Engineers Comments Regarding Surface Water Drainage

Application Reference:	LU/72/25/OUT (2)	Reviewer Reference:	ADC/SB
Planning Officer:	Emma Sheppard	Date of Review:	23/09/2025
Site Name:	Land to the West of New Courtwick Lane Wick BN17 7RZ		
Application Description:	Hybrid Planning Application comprising of the following: 1) - Outline application with all matters reserved (except access) for Phase 2 (West of Site) comprising development of approximately 8,800sqm GIA Light Industrial/Storage and Distribution (Use Class E(g)(iii) / B8), and 2) - Full Application for Phase 1 (East of the Site) for a food store (Use Class E(a)), 2 No. Drive-Thru food/beverage units (Sui Generis) with revised vehicular access, associated parking and landscaping. This application may affect the setting of a listed building and is in CIL Zone 2 and is CIL Liable.		
Assessment Number:	2 of 1

Engineers Comments Regarding Surface Water Drainage

Application Reference:	LU/72/25/OUT (1)	Reviewer Reference:	ADC/SB
Planning Officer:	Emma Sheppard	Date of Review:	23/09/2025
Site Name:	Land to the West of New Courtwick Lane Wick BN17 7RZ		
Application Description:	Hybrid Planning Application comprising of the

ISSUED FOR COMMENT.	AK	AK	17.10.25	P1
Description	By	Appld.	Date	Rev.
PRELIMINARY DRAWING NOT FOR CONSTRUCTION				
Title SuDS TESTING PLAN PHASE 1				
Project NEW COURTICK LANE, WICK LITTLEHAMPTON				
Client ROKEBY DEVELOPMENTS LTD				
Drawing No. 16785-HOP-ZZ-XX-DR-C-0920				
Status S2				
Rev. P1

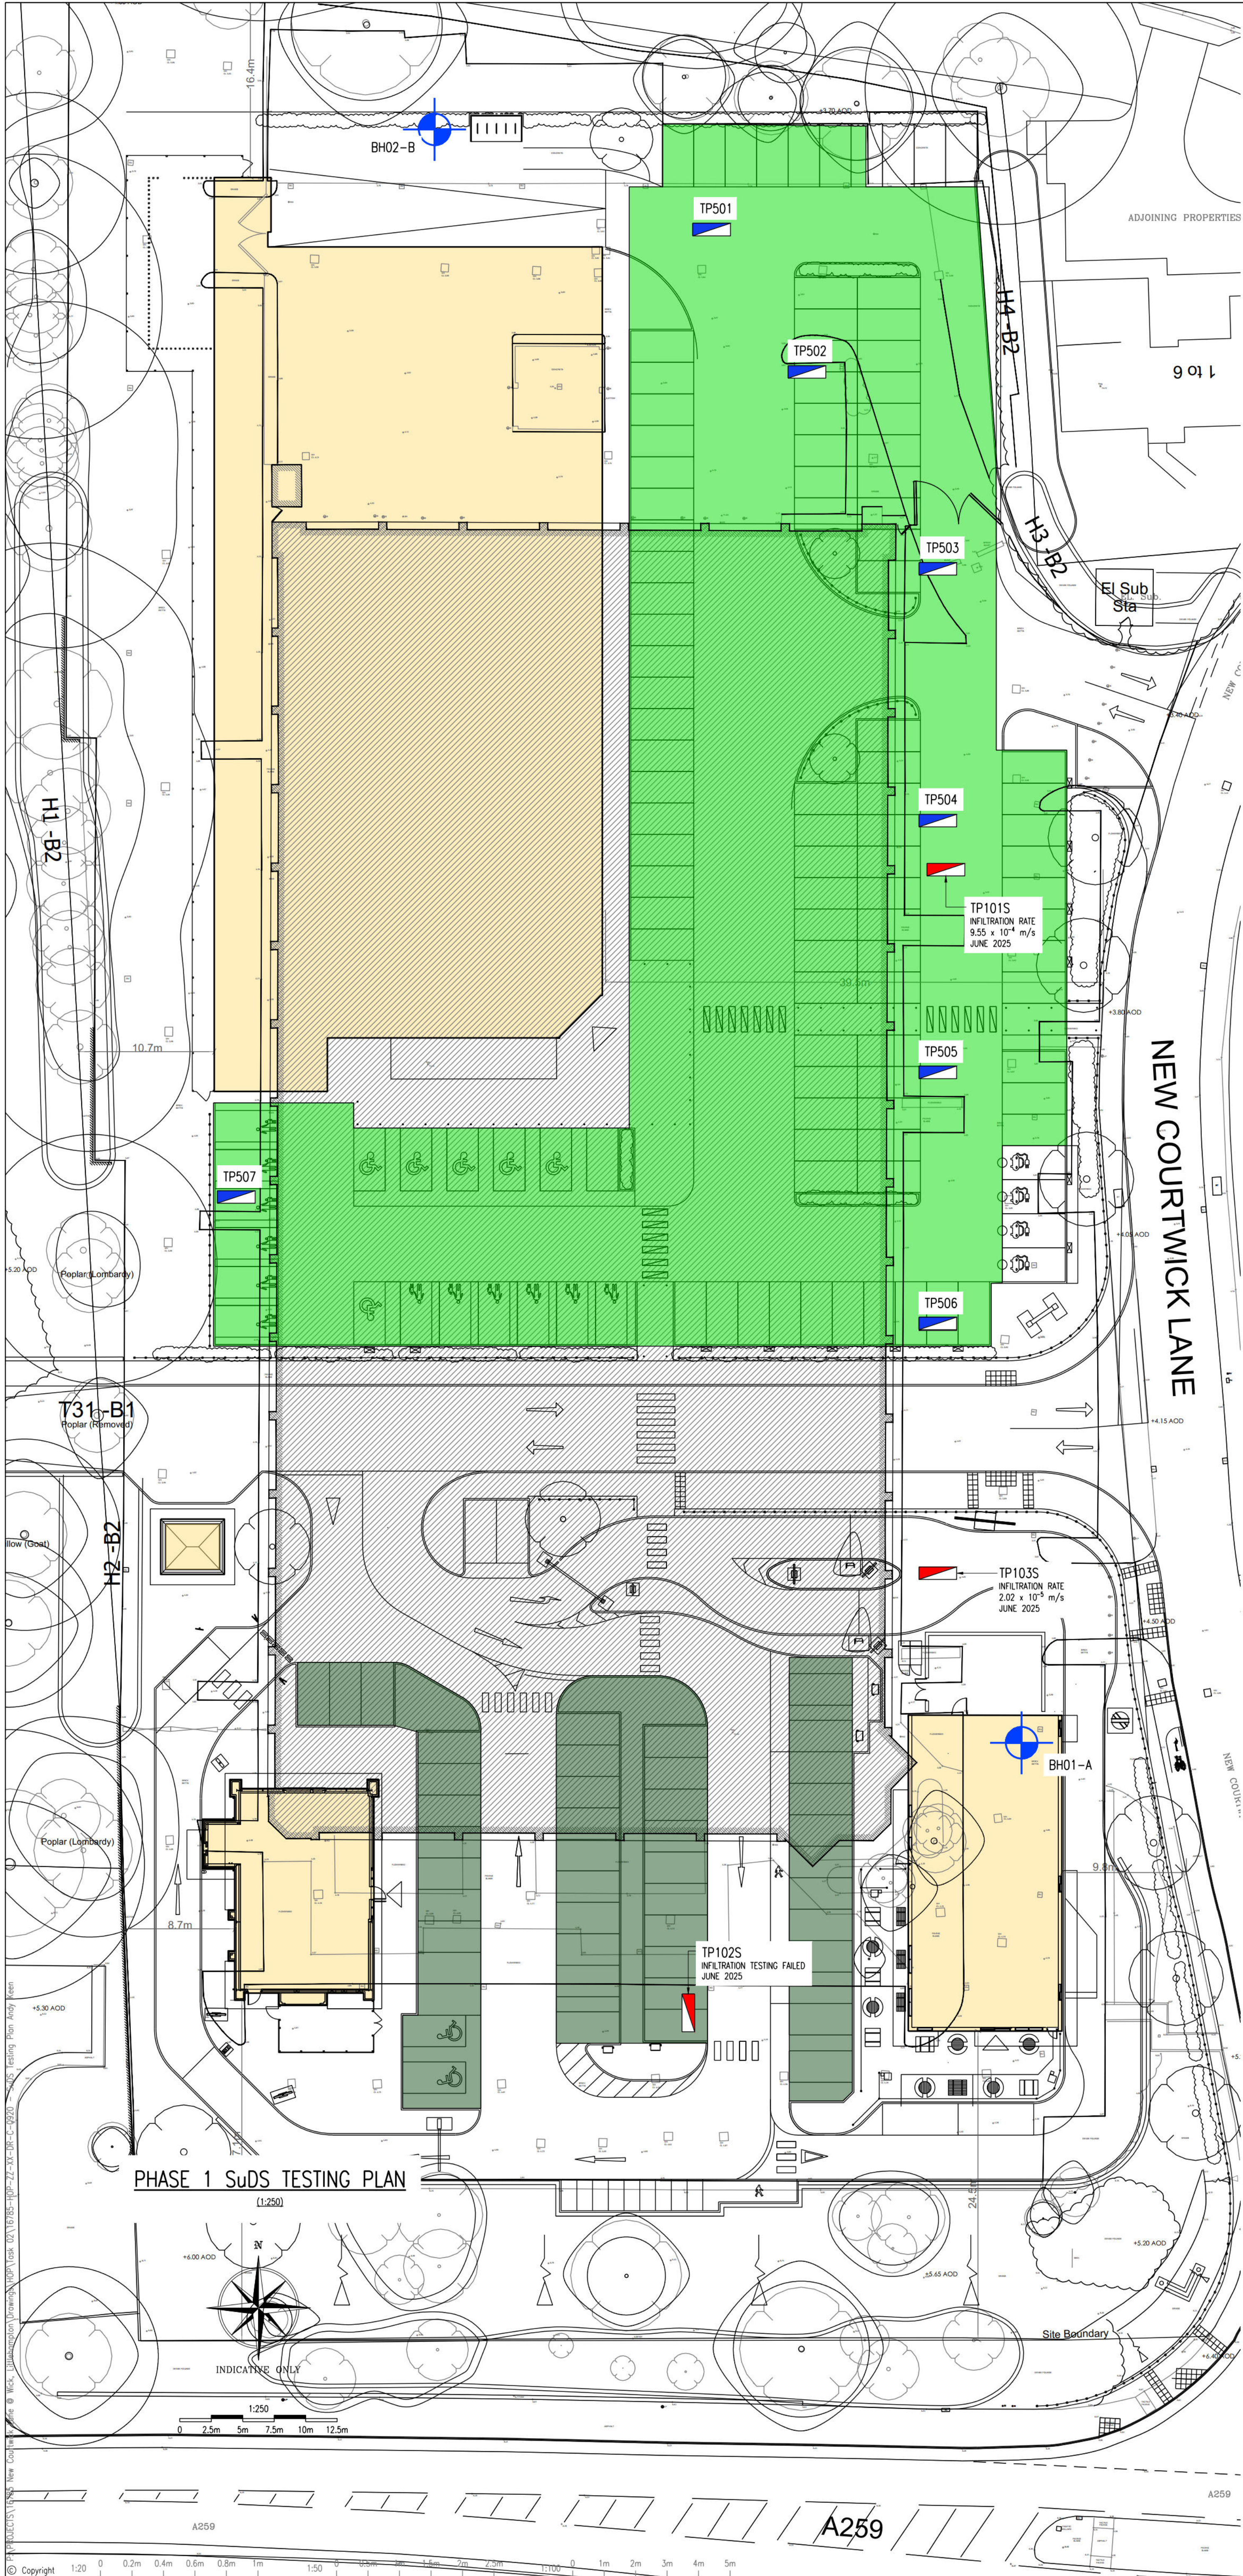
- 1.5. For the proposed 3800m² infiltration blanket, they have a single summer infiltration test within its area, and one further south outside of its area. This is an inadequate quantity of testing.

- 1.6. For context, BRE DG 365 states that testing should be completed every 25m along an infiltration feature to generate a design infiltration rate. For a feature of this size that would equate to approximately 7 tests spread evenly over the area, these tests must be at the depth and head of water to correspond with the design and completed in worst case conditions, which the guidance stipulates is in winter or spring.

- 1.7. The tests were completed at 0.85m below ground level (bgl), with a head of water of 0.45 and 0.55m. Yet the infiltration blanket is set 1.15m bgl, (deeper into the river terrace deposits), and with a design head of 0.85m. This does not replicate the testing.
